REQUEST

Current Zoning: N1-A (neighborhood 1-A)
Proposed Zoning: N1-D(CD) (neighborhood 1-D, conditional)

Approximately 12.77 acres located on the north side of Harris Houston Road, east of Kempsford Road, and west of Astoria Drive.

The petition proposes a residential development with up to 76 duplex units (in up to 38 buildings) on an internal street network with on street parking, common open space, and green and tree save areas on vacant land.

- **Proposed Request Details**

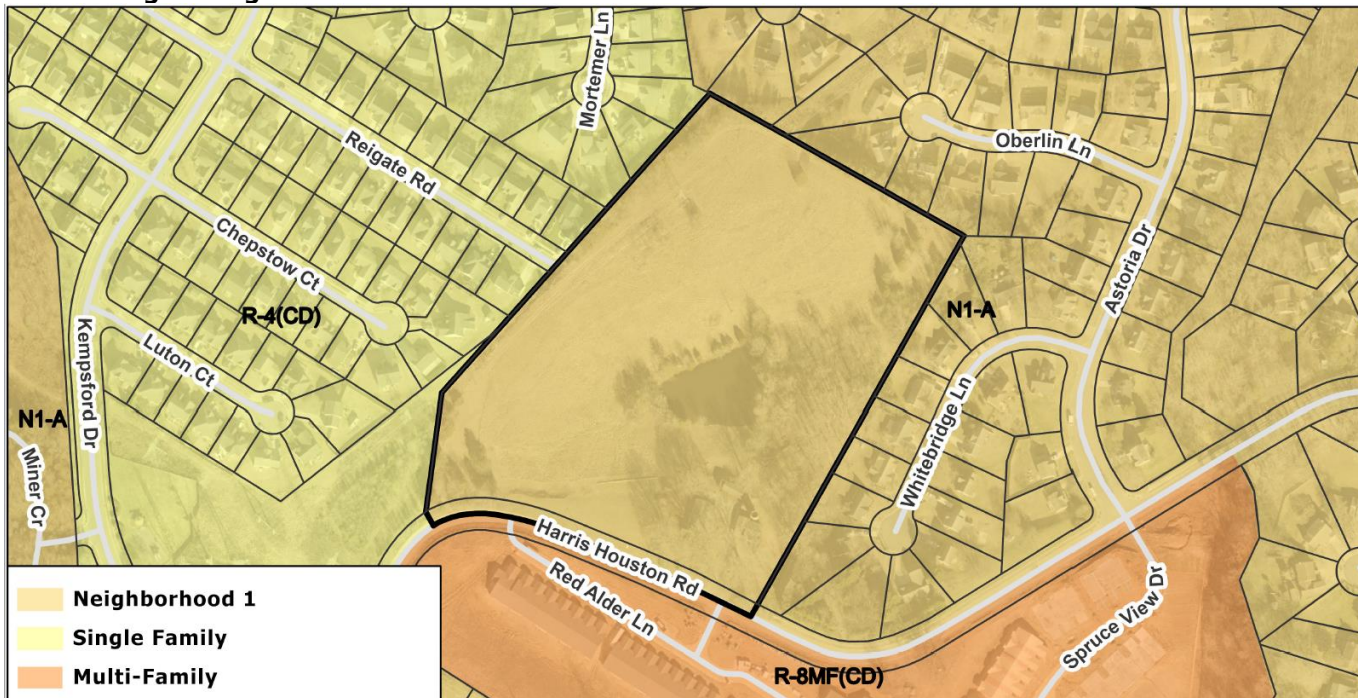
3. Review green area standards. Many areas shown as green area do not meet green area standards including min width, 10' no build zones and showing utilities within tree save/green areas. **Not addressed**
4. Most of the existing tree canopy is shown as common open space and the majority of the tree save is replanted. Adjust the tree save and common open space so the bulk of the tree canopy is tree save. Still showing sight distance triangles within tree save. **Not addressed**
